Camden Council

29 March 2018

RE: State Significant Application DA 75/256 MOD 4

**PROPERTY: 172 and 186 Macarthur Road, Spring Farm
Lot: 32, DP: 635271
Lot: 22, DP: 833317**

NOISE COMPLIANCE TESTING AND INSPECTION

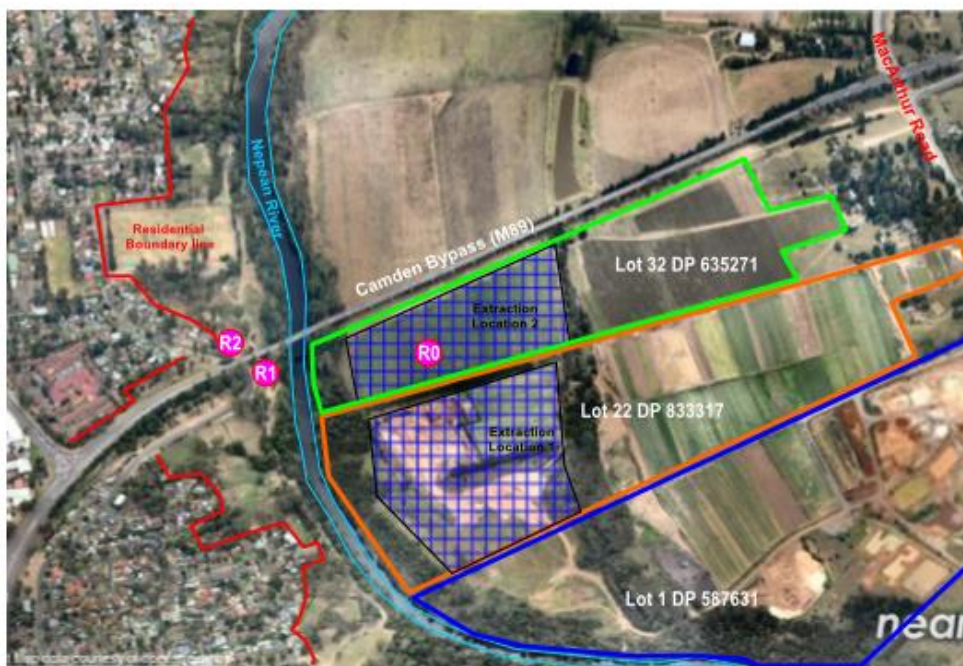
- The application has been accompanied by noise compliance testing that undertook noise monitoring at three locations. The applicant should clarify why the compliance check did not take into account ongoing noise from the quarry's processing area at 214 Macarthur Road, Spring Farm. It is acknowledged that the processing area operates under a separate Council development consent. However the extended timeframe for the quarry operations will also involve the use of the processing area.

Council officers consider that the noise compliance check should include noise from the processing area at 214 Macarthur Road. It is noted that a new residential subdivision is currently being constructed immediately adjoining the south eastern boundary of the processing area.
